DECISION DELEGATED TO HEAD OF PLANNING

Application No: H02-0758-24 **Applicant:** Mr R East

Proposal: Proposed extensions to front and rear of dwelling

Location: Threeways French Drove Crowland

scale 1:500 PRINT AT A4	date JULY 2024	revision A 25/07/2024 DRAWING FIRST ISSUED
title PROPOSED SITE PLAN.

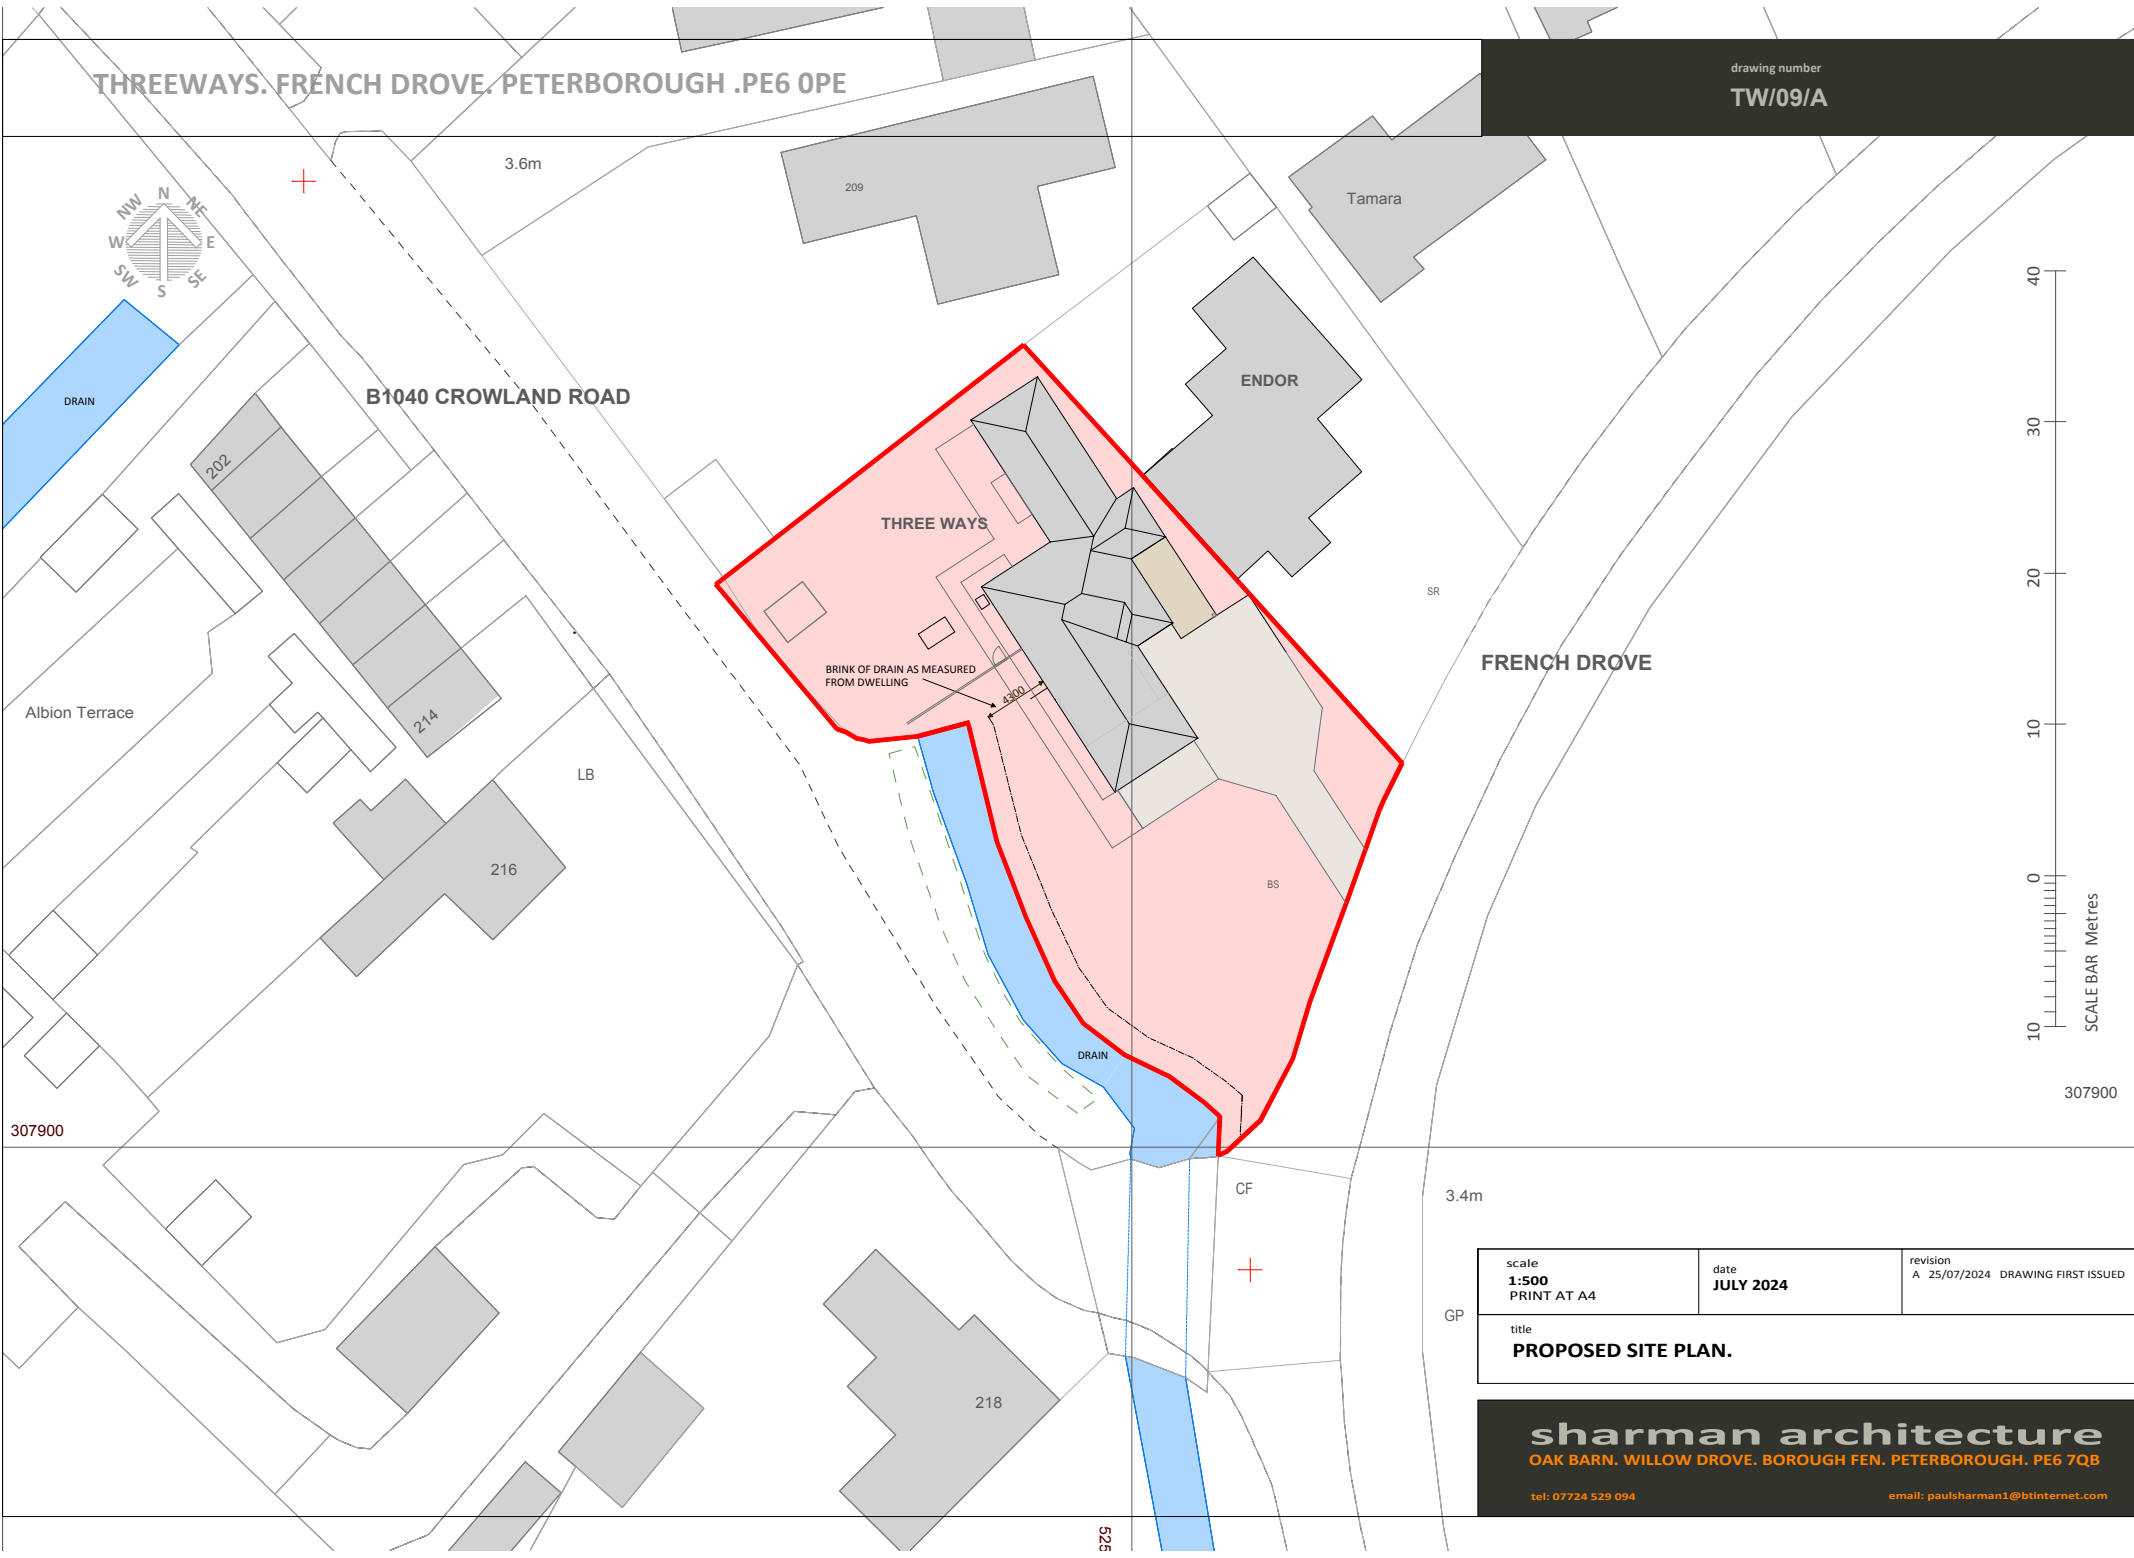
The proposal is for extensions to front and rear of dwelling. The Property will remain a 2 bed with the proposal. There is enough space for cars to enter and leave in a forward gear in addition to adequate parking spaces for the size of dwelling. The proposal will not have an adverse impact on the public highway. As Lead Local Flood Authority, Lincolnshire County Council is required to provide a statutory planning consultation response with regard to drainage and surface water flood risk on all Major applications. This application is classified as a Minor Application and it is therefore the duty of the Local Planning Authority to consider the surface water flood risk and drainage proposals for this planning application.

title
PROPOSED GROUND FLOOR PLAN

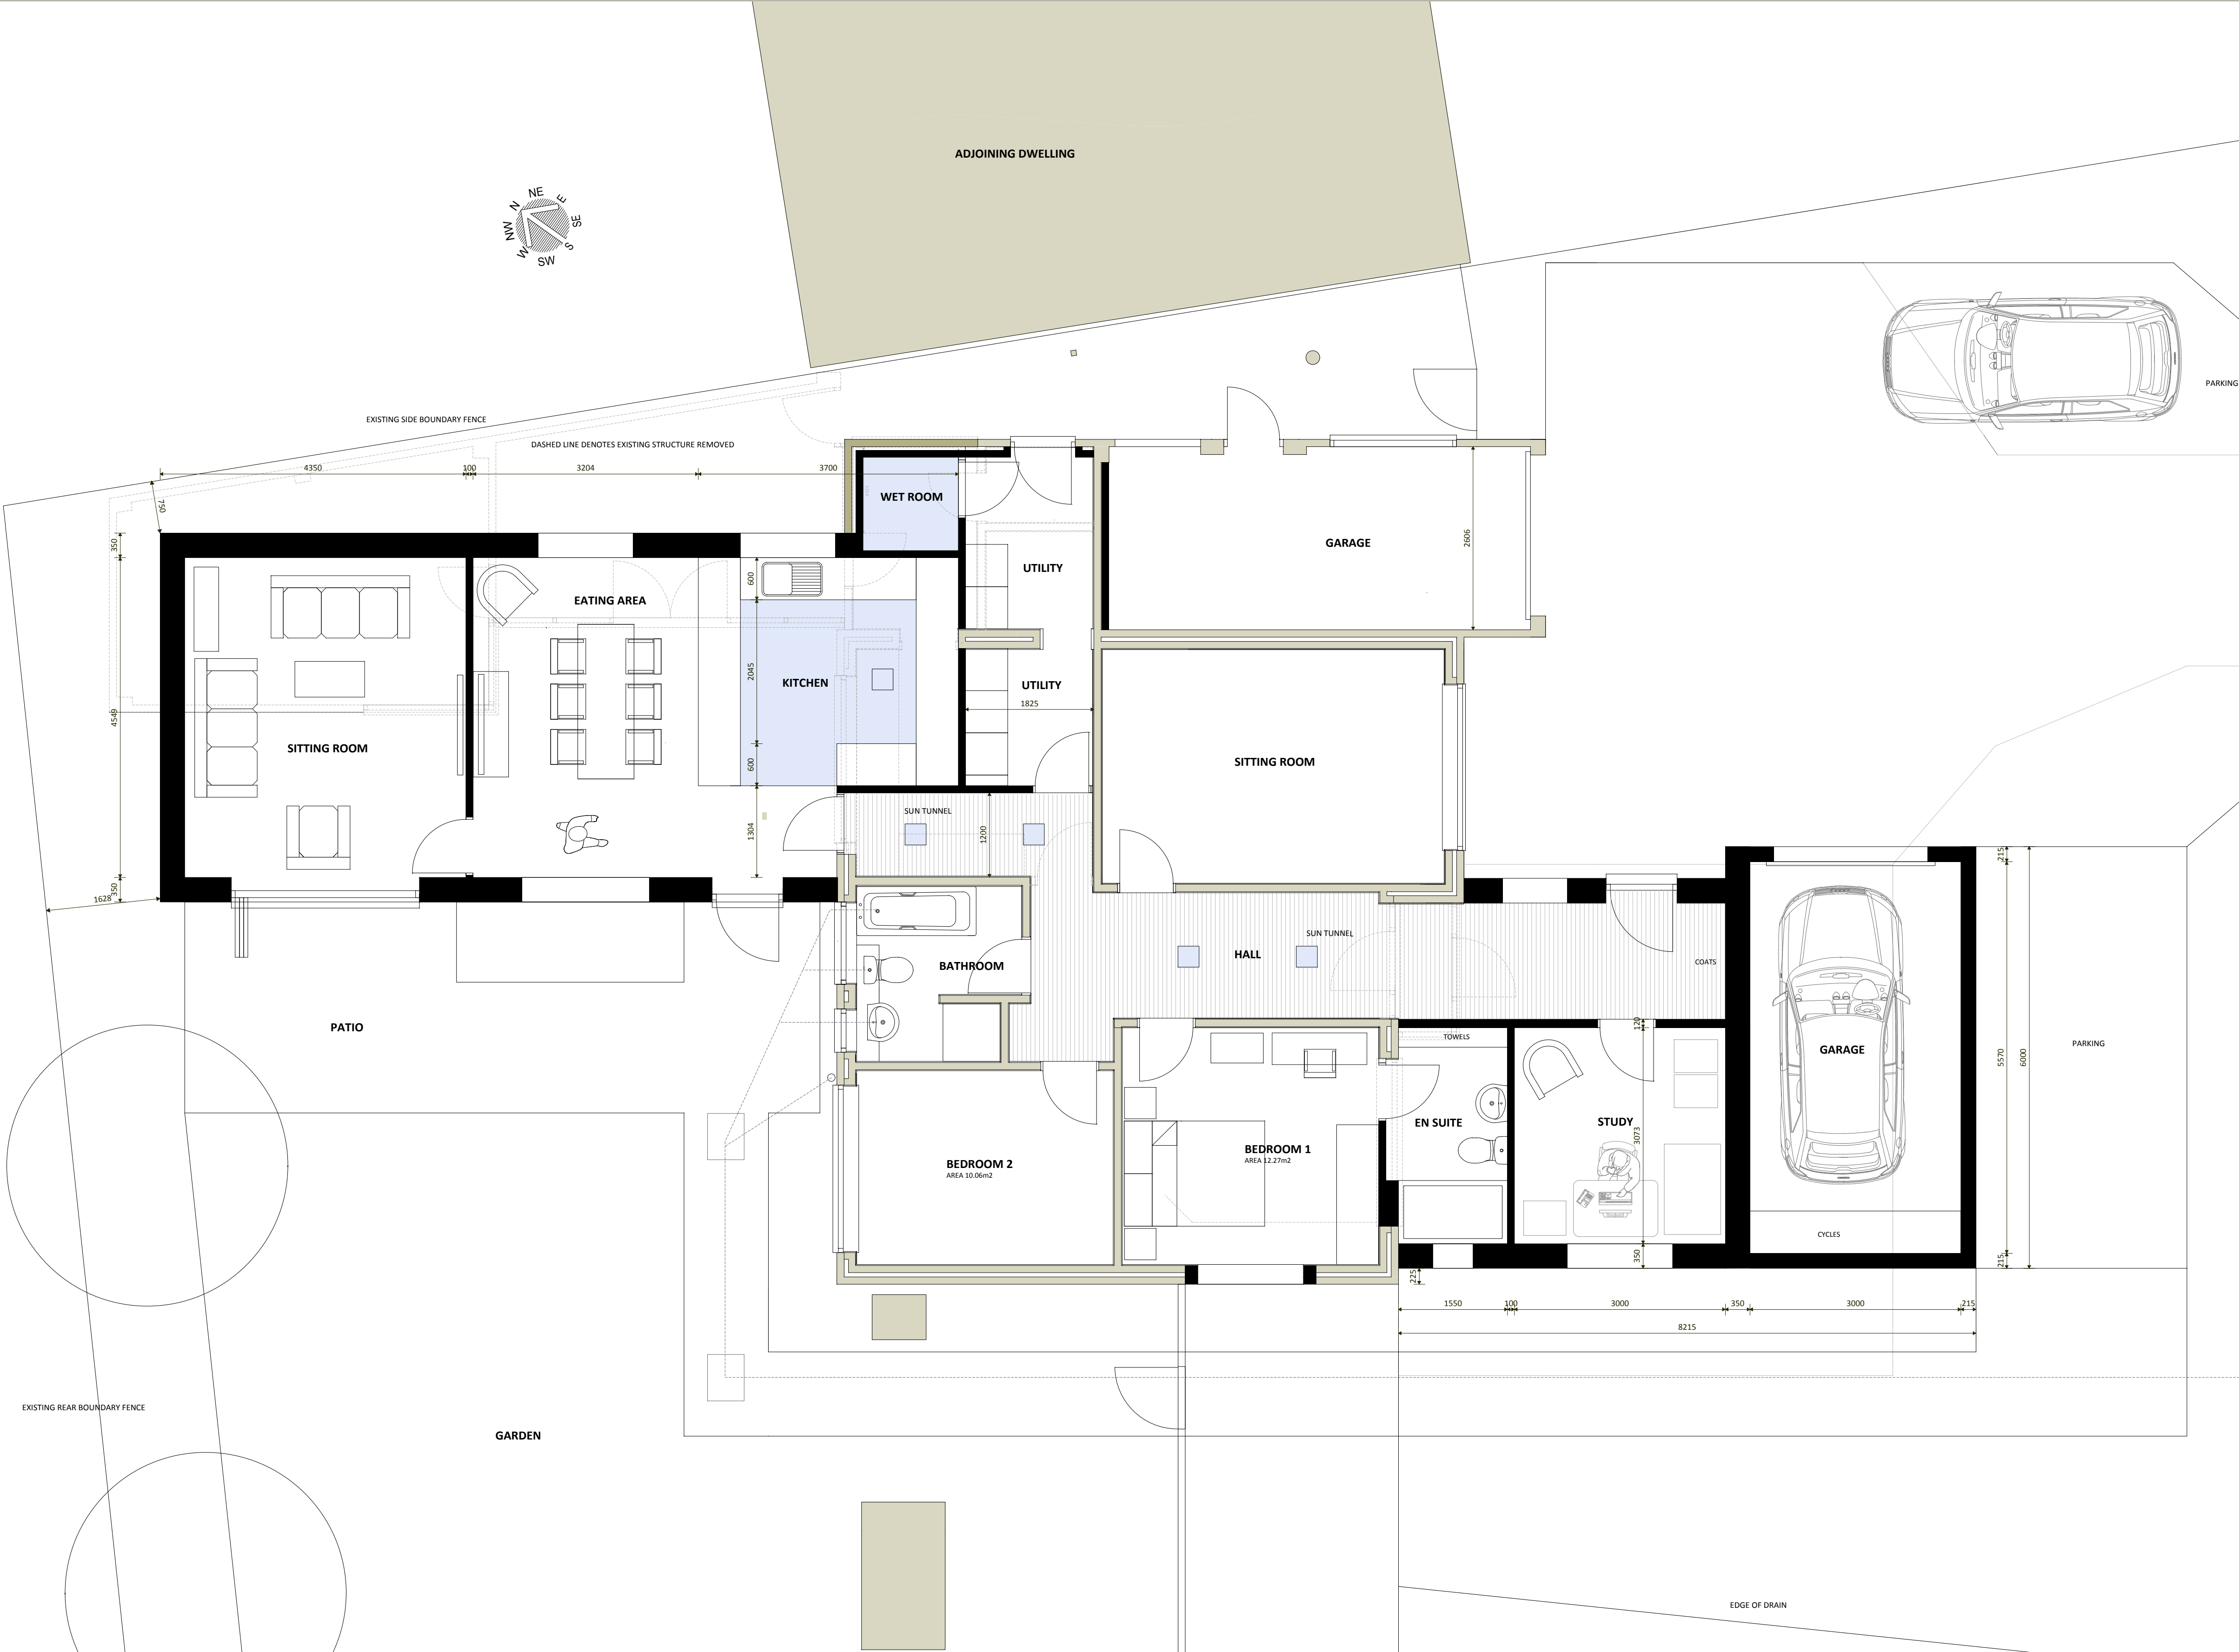
The proposed extension would protrude from the front elevation by approximately 3348mm, with a width of 5548mm. This addition would result in a projection beyond the existing front elevation, including that of the existing garage projection. However, this additional projection would be modest.

To the rear, in order to accommodate for the new layout, the existing rear projection that runs along the boundary of the site would be demolished, with the proposed rear extension being constructed in its place; albeit providing a further degree of separation to the boundary. This extension would be slightly shorter in projection and would sit with an increased separation distance to the boundary. In total, the extension would run a total of 11354mm, when viewed inclusive of the wet room within the internal redesign; however, this is considered to be acceptable when viewed in respect of the existing rear projection currently present on site. In addition to this, there would also be further alterations in this area as the new extension would feature a hipped roof, rather than a flat roof which would match the existing dwelling and should appear more visually appealing.

As part of the development some internal works would also be carried out to the floor plan and layout. These include, but are not limited to, the new front extension featuring a cloak room and ensuite for Bedroom 1 as well opening up the hallway area slightly to feature a 'Sun Tunnel'. The existing utility shall also be opened up into the kitchen area to incorporate a wet room, whilst the kitchen is to be moved into the rear section of the bungalow. An open plan eating area will sit adjacent to the kitchen with a sitting room in the rear most part. The proposed alterations are considered to be suitable and do not necessarily require planning permission but have been included in the plans and therefore assessed in the report - they should not create any material harm to the area.

The proposal would introduce windows to the side elevation of the 'eating area' and kitchen, facing towards the direct neighbour. Notwithstanding their location, these windows would face directly at an existing side boundary fence and therefore, given the siting and height of the property, should not create any material overlooking in this instance. Furthermore, there should also be no material overshadowing despite the increase in roof height due to the positioning of the plots; any overshadowing created would be minimal and would be at the latest point in the day when the sun is at its lowest point.

title PROPOSED ELEVATIONS	scale 1:100 @ A3	date SEPTEMBER 2024
contract MR RICHARD EAST	revision A 02/09/2024 Drawing first issued

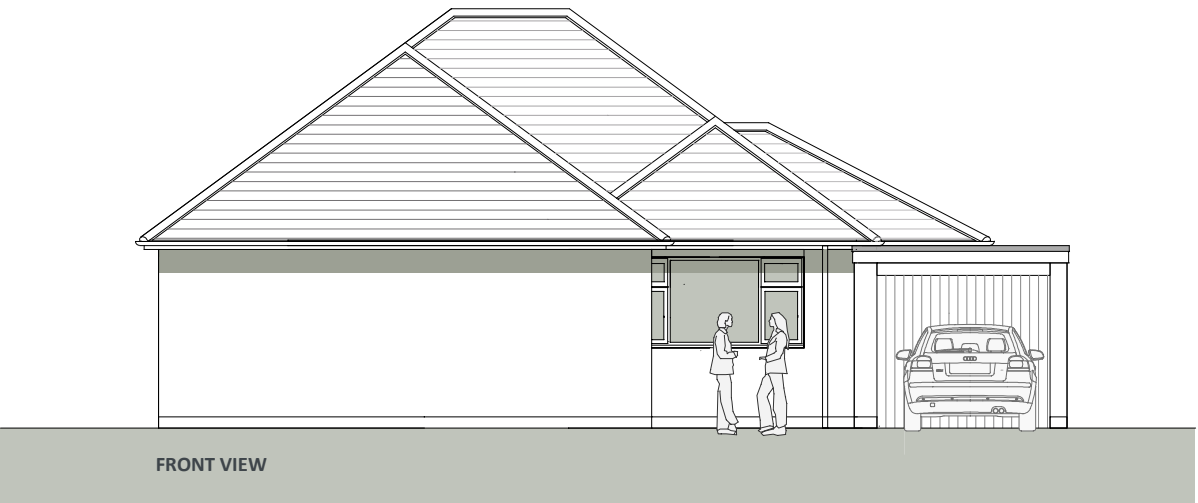
In reference to the roof height, the eaves would be level throughout with the ridges varying in height; although no roof would be higher than the existing and therefore ensuring the extension will appear subservient and subordinate further benefitting the scheme.

The materials would also match those of the existing property throughout which ensures the extension would remain in keeping with the host property. The walls would be constructed from clay brickwork with the roof using concrete tiles. The windows and doors shall be constructed from white uPVC.
